COMMUNITY SERVICES DEPARTMENT

Subject: Forest Lakes Phase II PUD Development Plan/Preliminary Plan (PUDSP-18-001)

The Planning Division of the Community Services Department has reviewed the Forest Lakes Phase II PUD Development Plan/Preliminary Plan, and has the following comments of behalf of El Paso County Parks. This application will be presented to the Park Advisory Board February 13, 2019.

3
10 COUNTY TRAIL- STANDARD TIER 1 DETAIL

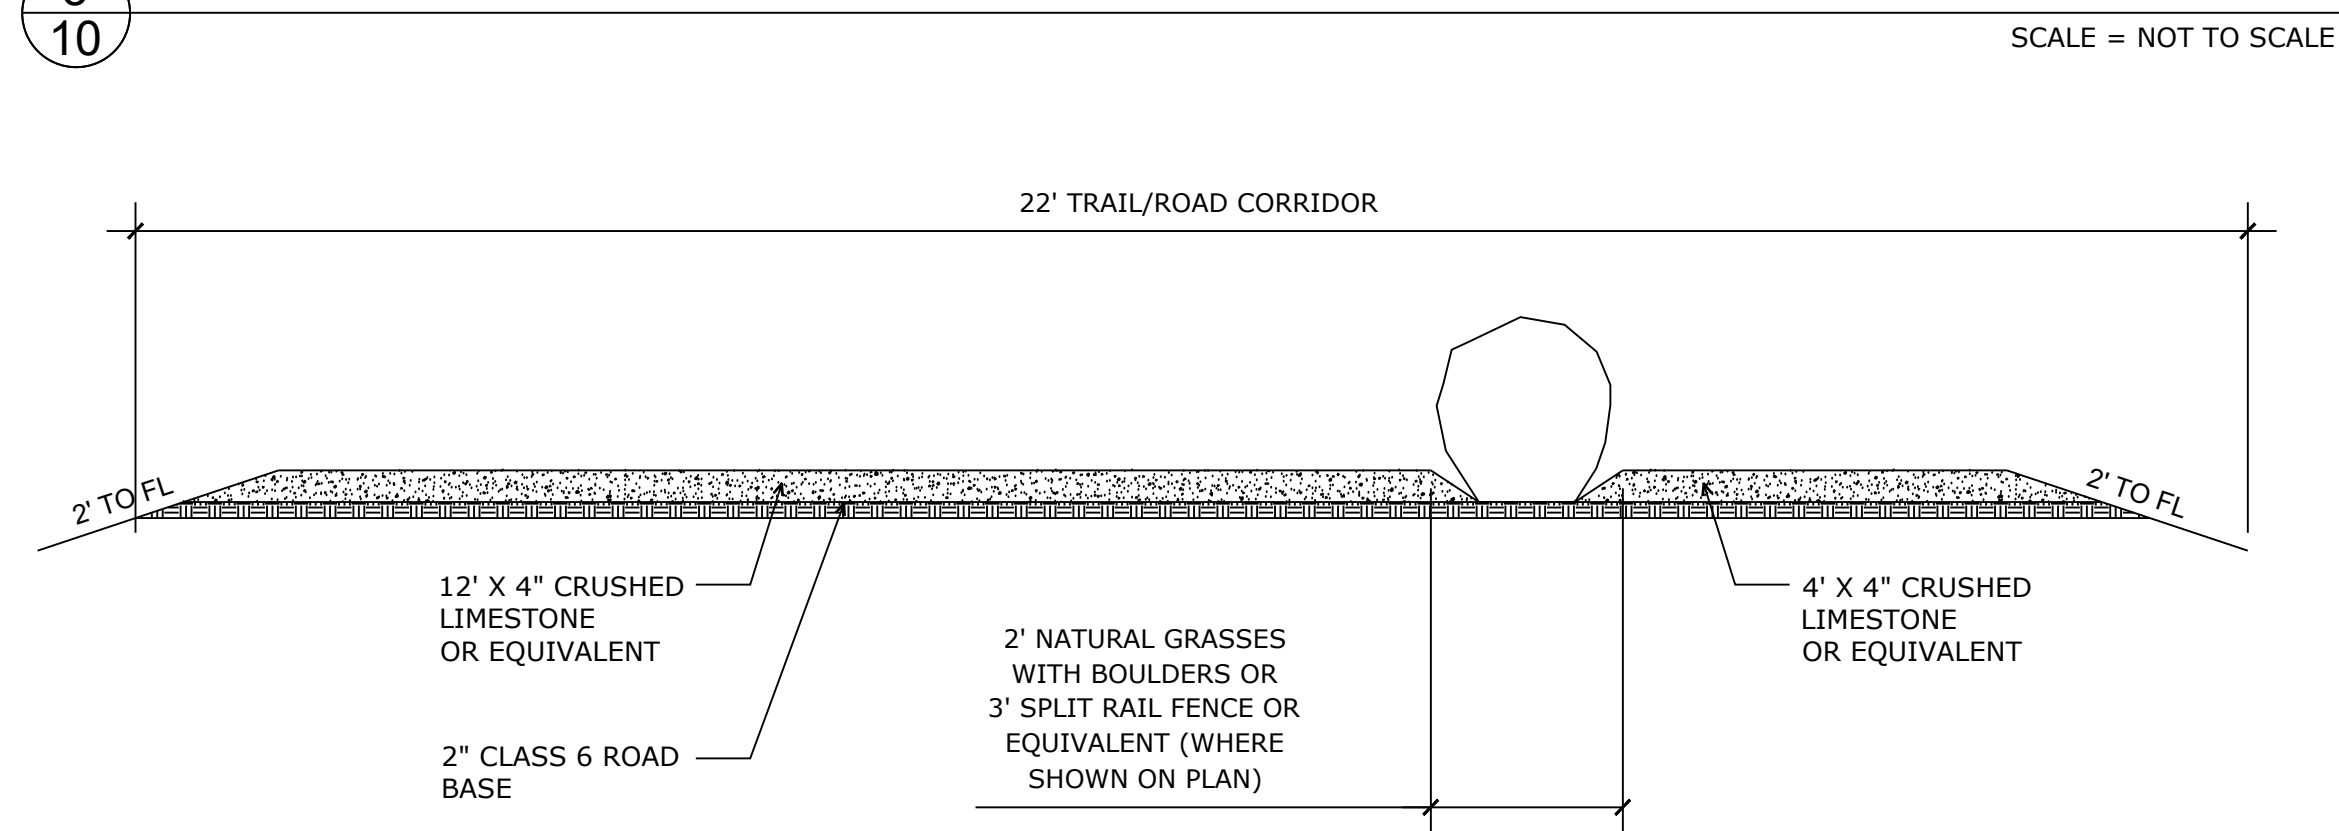
- The trail shall be constructed to Tier 1 standards for a primary regional trail.
- The trail shall be maintained by the Forest Lakes Metropolitan District when contained within the developer-owned tracts, while El Paso County agrees to maintain the trail contained within the right-of-way of Forest Lakes Drive and the designated school property easement.
- Encourage the developer to explore the development of an informal crusher fines trail in Tract C to connect the terminus of the Forest Lake Secondary Regional Trail southward to sidewalks and other proposed trails along Mesa Top Drive.

4
10 COMBINED EMERGENCY ACCESS ROAD & COUNTY TRAIL DETAIL

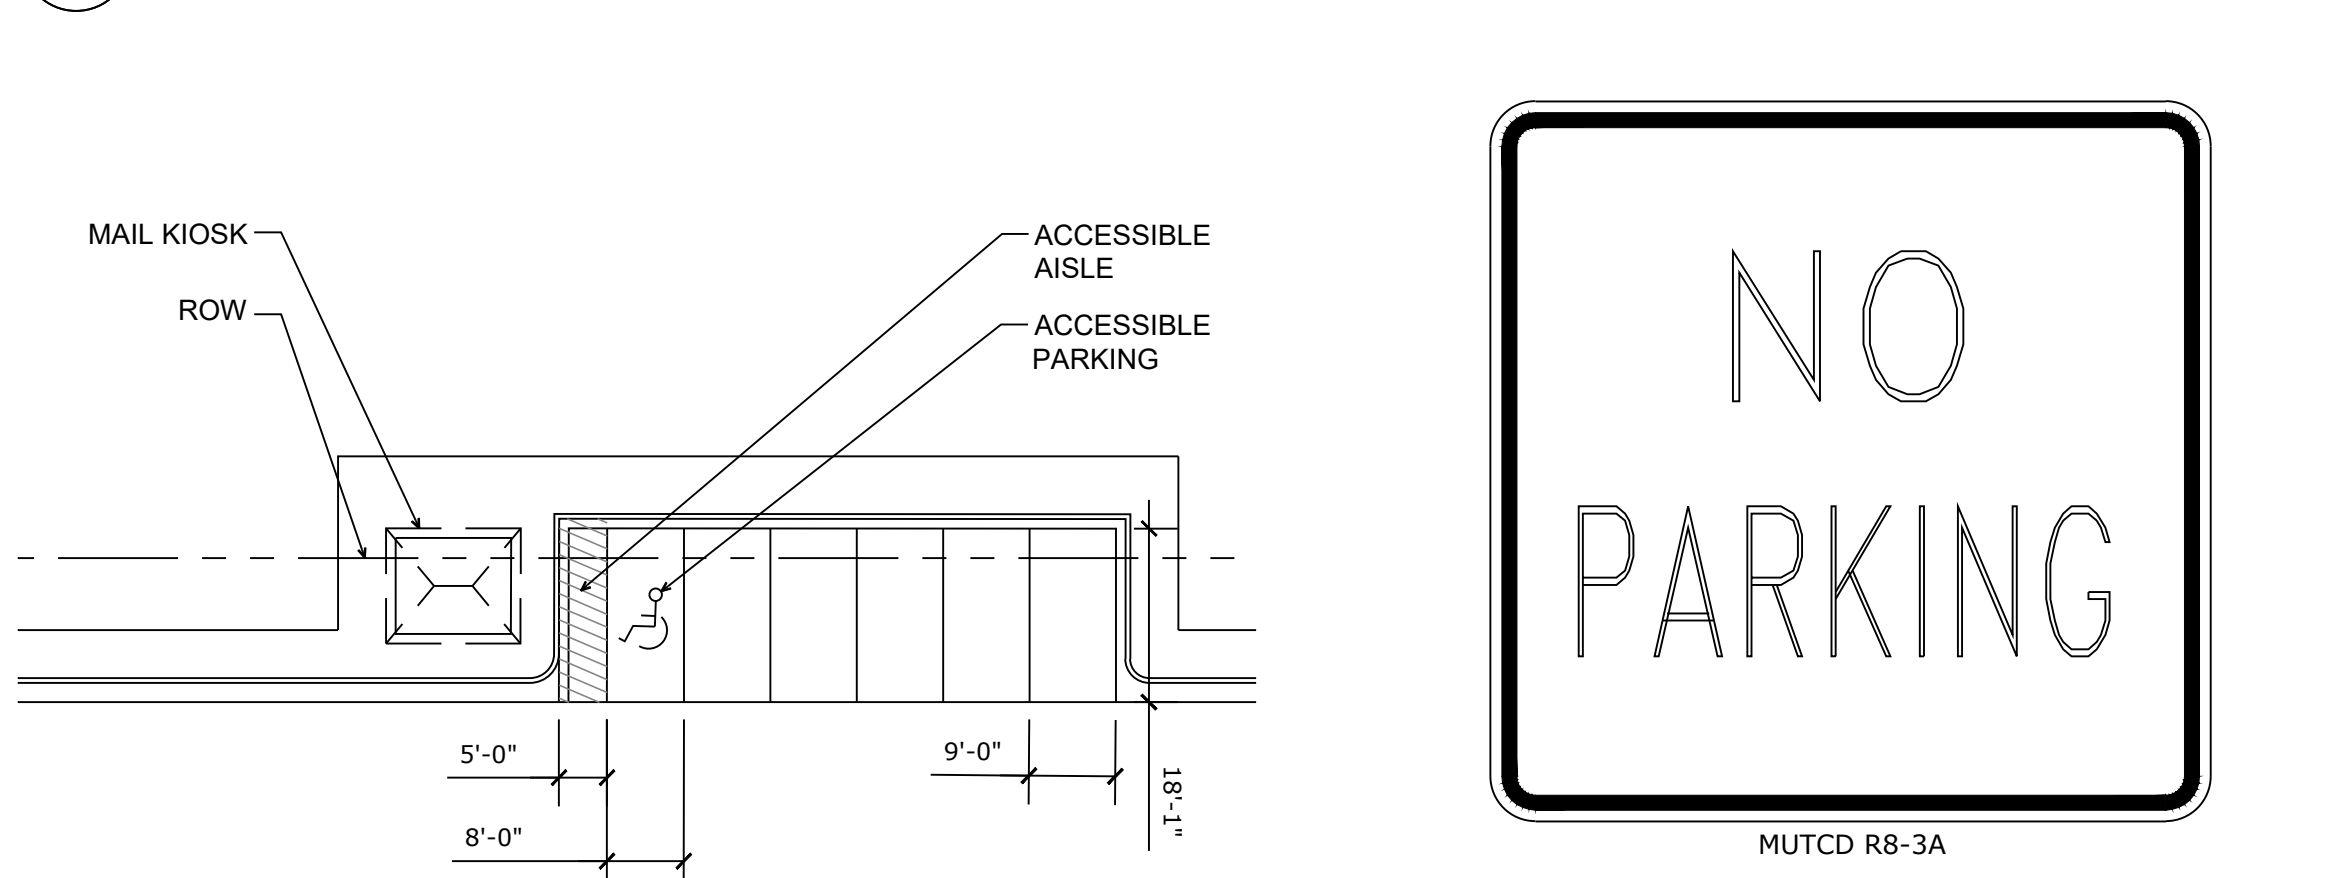
The applicant has also requested that a portion of the Forest Lakes Secondary Regional Trail be utilized as an emergency access route. In early February 2019, Parks staff and the applicant agreed to locate the regional trail immediately adjacent the emergency access road, to be separated by boulders sourced from the site and natural grass. Where the trail and emergency road intersect local streets, a short length of post-and-dowel fencing would help to delineate the road from the trail. The details of this arrangement are notated and depicted on the attached draft Page 4 of the PUD Preliminary Plan.
